Stormwater GEC Plan comments.pdf Markup Summary

[4] G-4 Initial Erosion Control Plan South (4)

INITIAL EROSION CONTROL PLAN SOUTH
HONOR CHARTER SCHOOL
HIGHMARK SCHOOL DEVELOPMENT
8250 BENT GRASS MEADOWS DR.

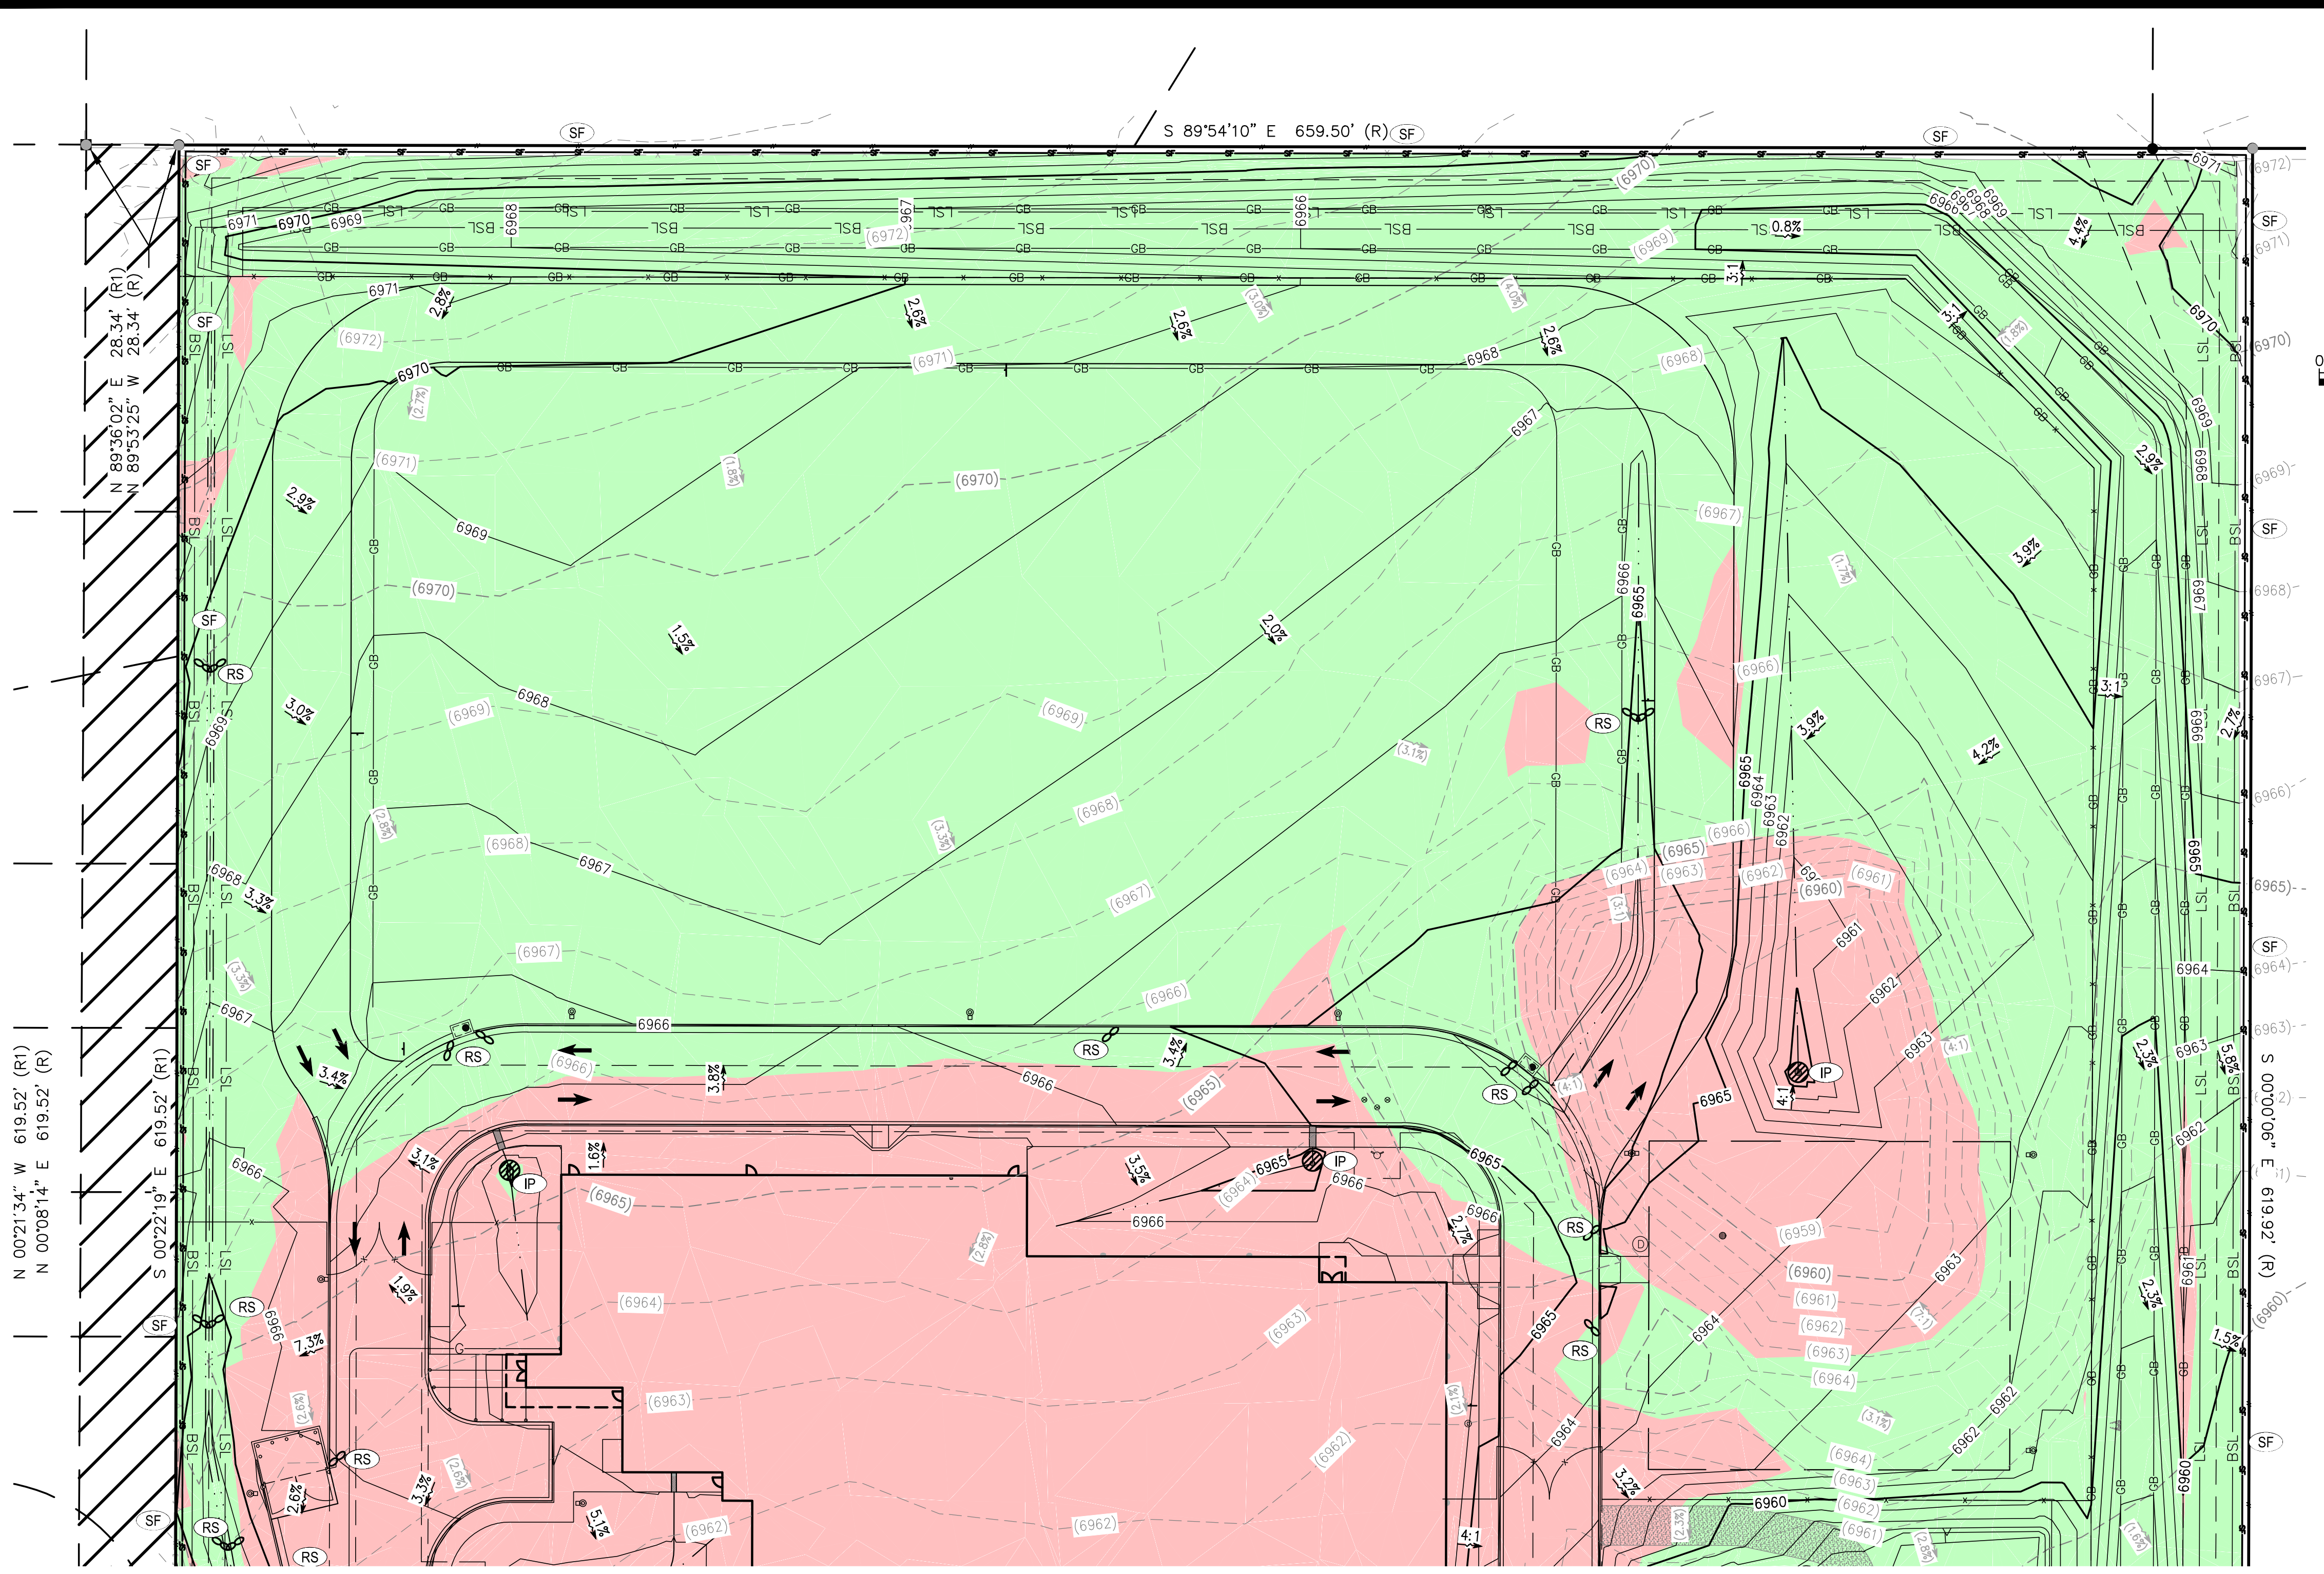
Please provide a detail for the sediment basin and show the proposed outlet pipe on the plans. I know this site is flat and it might be difficult to daylight the traditional outlet pipe, a few alternatives you could consider are the skimmer floating outlet or a pump to a dewatering bag (see screenshots from MHFD details below). For the pump you would have to specify in the SWMP that it would run whenever standing water was present in the basin.

I think the colors are reversed. The map says the low spots are in a cut area.

TAIT Response:
A detail for the sediment pond and outlet was provided on sheet G-14. The sediment basin note has been updated to allow for a pump/dewatering process should the site prove to be too flat for a gravity outlet.

TAIT Response:
The legend has been updated
